Please ask for: Mrs D Johnson
Email: daun.johnson@arun.gov.uk
Telephone: 01903 737762
Our Ref: P/19/22/PL
Your Ref:
Date: 23rd February 2022

Application for Planning Permission

Development: Erection of a Jump Tower with Climbing Wall and a Container Bar. This application may affect the setting of listed buildings and is in CIL Zone 4 (Zero Rated) as other development.

Location: Church Farm Holiday Village Church Lane Pagham PO21 4NR

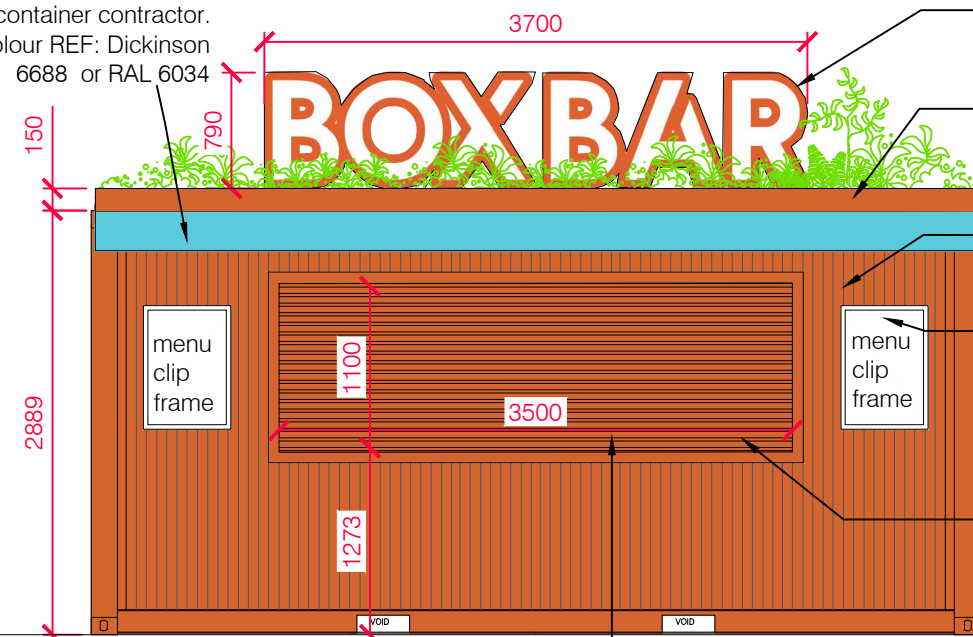
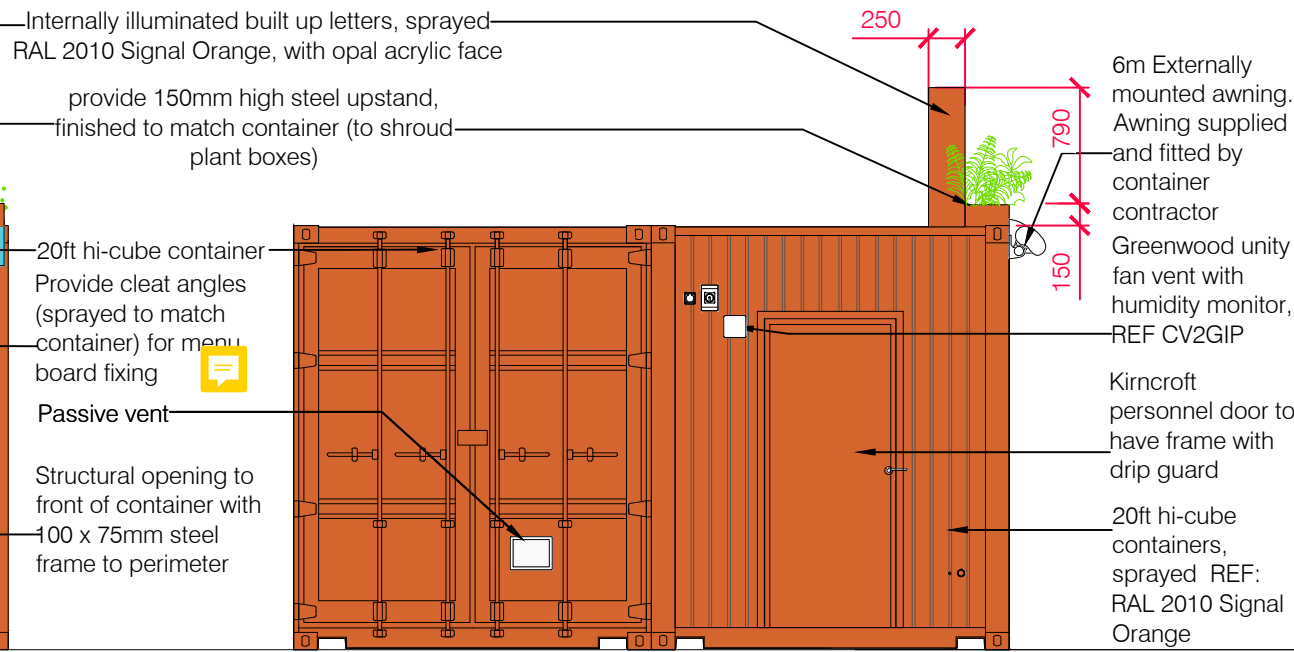
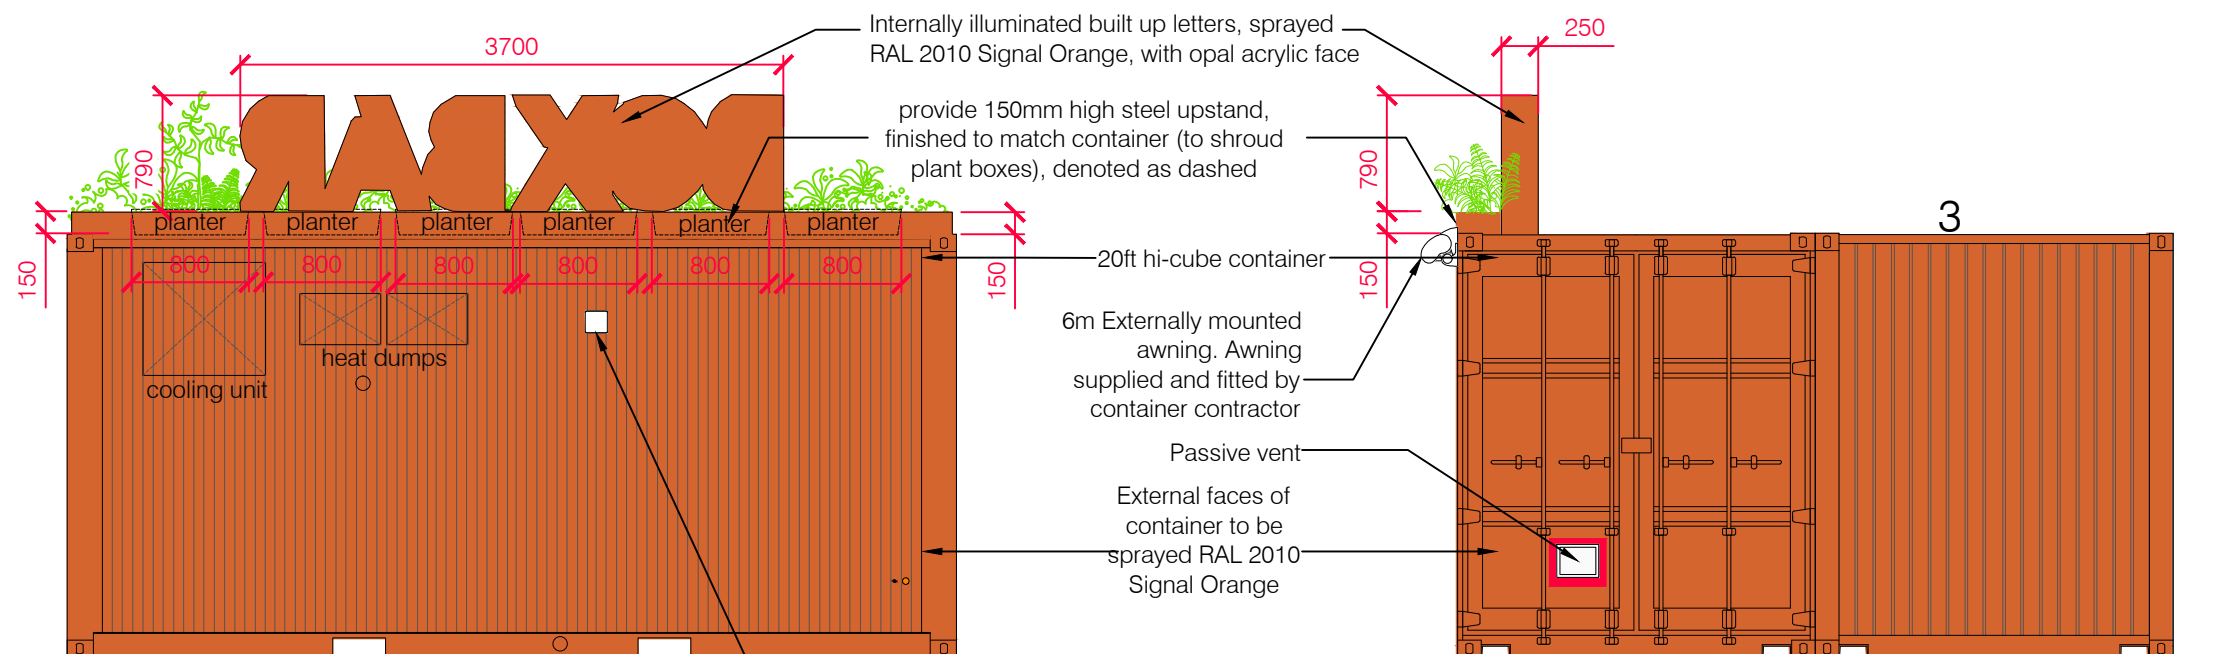
Please provide details of the cooling unit on the Box Bar.
